Your Ref: 2025/90320

9th April 2025

Jewson Property And Services Division, St Andrew's Road, Huddersfield - Erection of extension to existing warehouse; demolition of warehouse entrance canopy and southern section of existing warehouse; demolition of existing timber storage area and erection of covered external racking area and associated works

Proposed Layout Plan Showing Catchment Areas (1:1000)

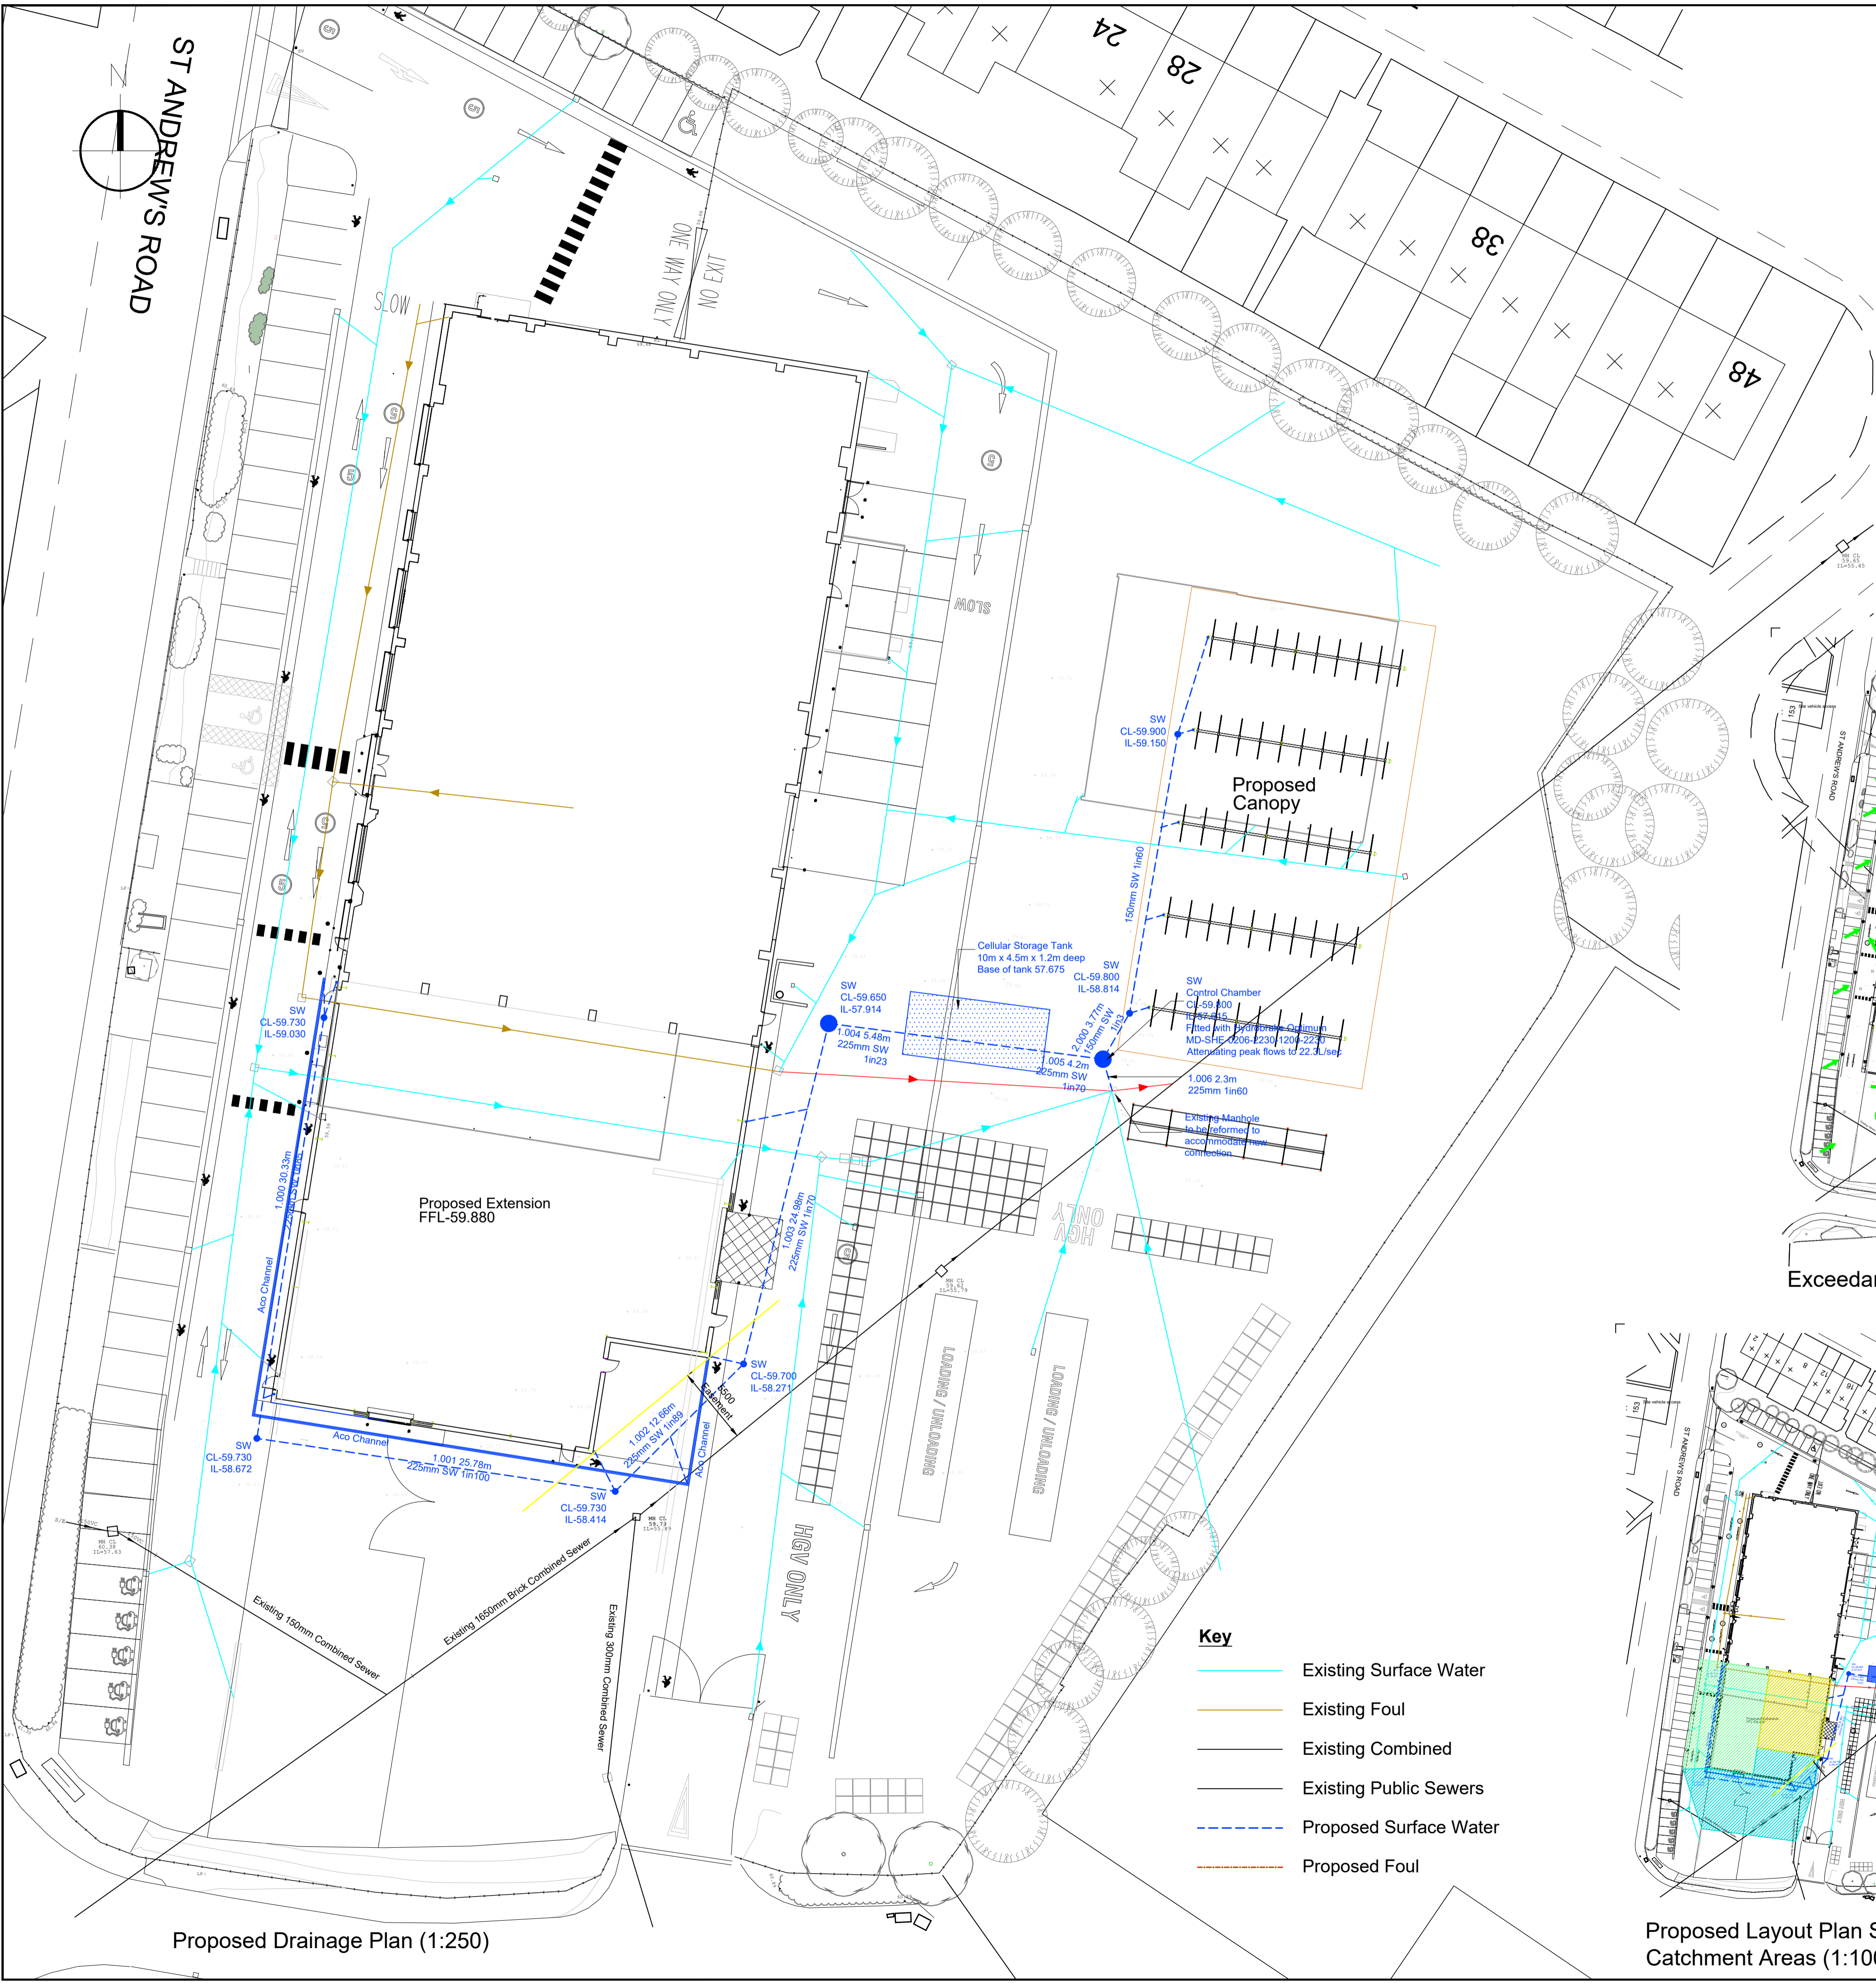
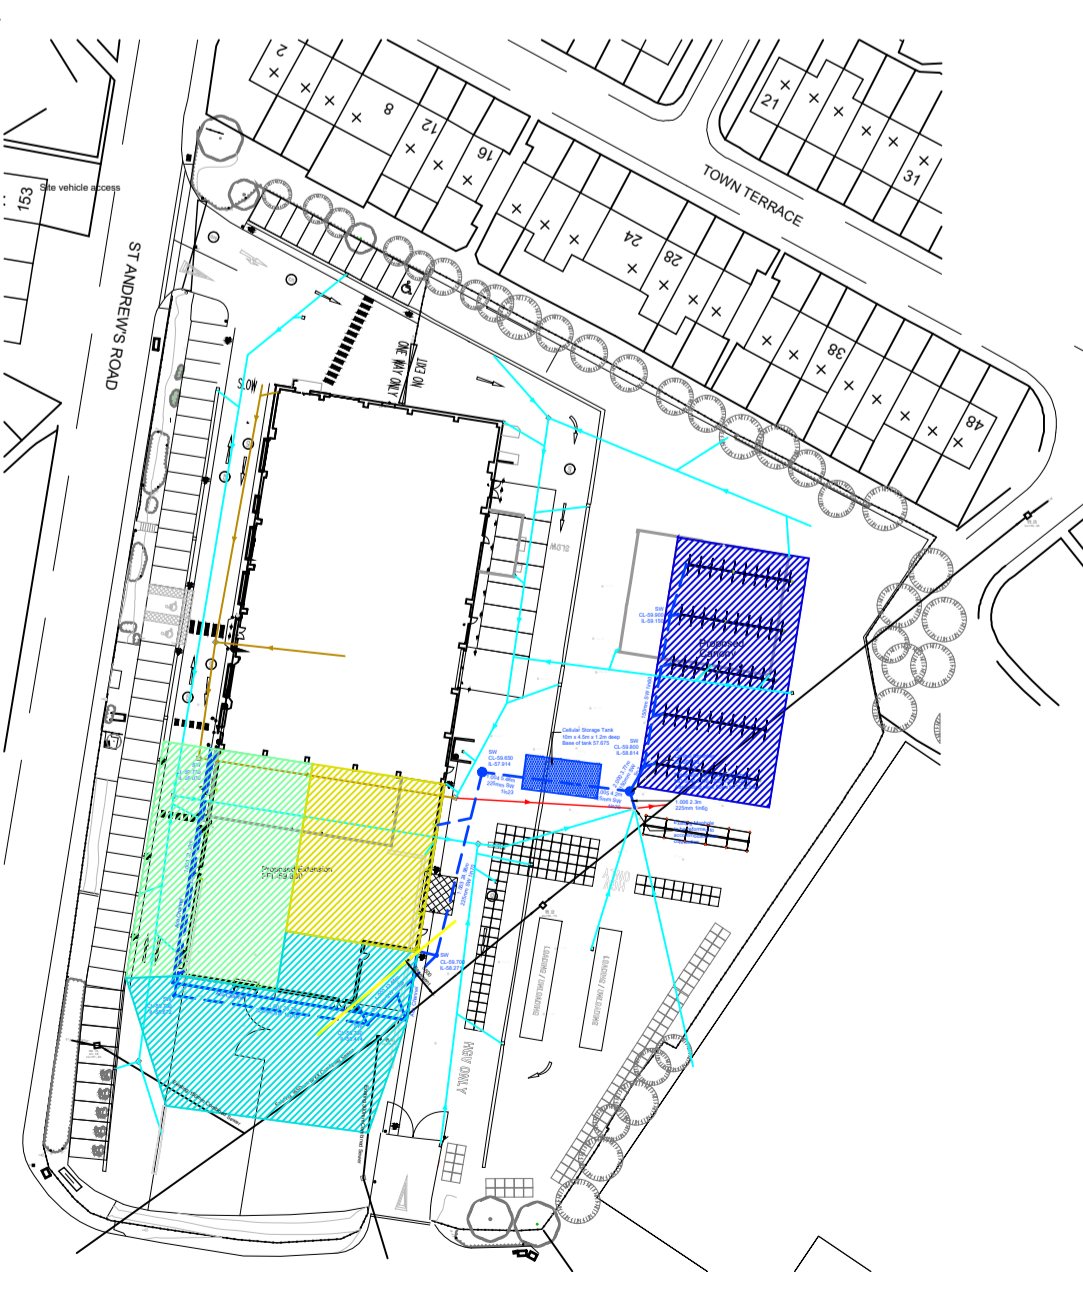
The development shall be carried out in accordance with the details shown on the submitted plan, 24399-DR-C-0102 dated December 2024 that has been prepared by Topping Engineers, unless otherwise agreed in writing with the Local Planning Authority. (In the interest of satisfactory and sustainable drainage)

1) Yorkshire Water has no objection in principle to:

- a) The proposed separate systems of drainage on site with combined off-site
- b) The proposed amount of curtilage surface water to be discharged to the public combined water sewer at a restricted rate of 22.34 litres/second
- c) The proposed point of discharge of foul and surface water to the public 1650mm diameter combined sewer

submitted on drawing 24399-DR-C-0102 dated December 2024 that has been prepared by Topping Engineers.

2) On the Statutory Sewer Map, there is a 165mm, 300mm and 150mm diameter public combined water sewer recorded to cross the site. It is essential that the presence of this infrastructure is taken into account in the design of the scheme.

- a) It may not be acceptable to raise or lower ground levels over the sewer and we will not accept any inspection chambers on the sewer to be built over.
- b) In this instance, a stand-off distance of 6.5 (six point five) metres is required at each side of the 1650mm diameter combined sewer centre-line and it may not be acceptable to raise or lower ground levels over the sewer, nor to restrict access to the manholes on the sewer.
- c) In this instance, it would appear that the 150mm and 300mm diameter public sewer is unlikely to be affected by building-over proposals.
- d) A proposal by the developer to alter/divert a public sewer will be subject to Yorkshire Water's requirements and formal procedure in accordance with Section 185 Water Industry Act 1991.

3) Surface water run-off from communal parking (greater than 800 sq metres or more than 50 car parking spaces) and hardstanding must pass through an oil, petrol and grit interceptor/separator of adequate design before any discharge to the public sewer network.

Roof water should not pass through the traditional 'stage' or full retention type of interceptor/separator and it is good drainage practice for any interceptor/separator to be located upstream of any on-site balancing, storage or other means of flow attenuation that may be required.
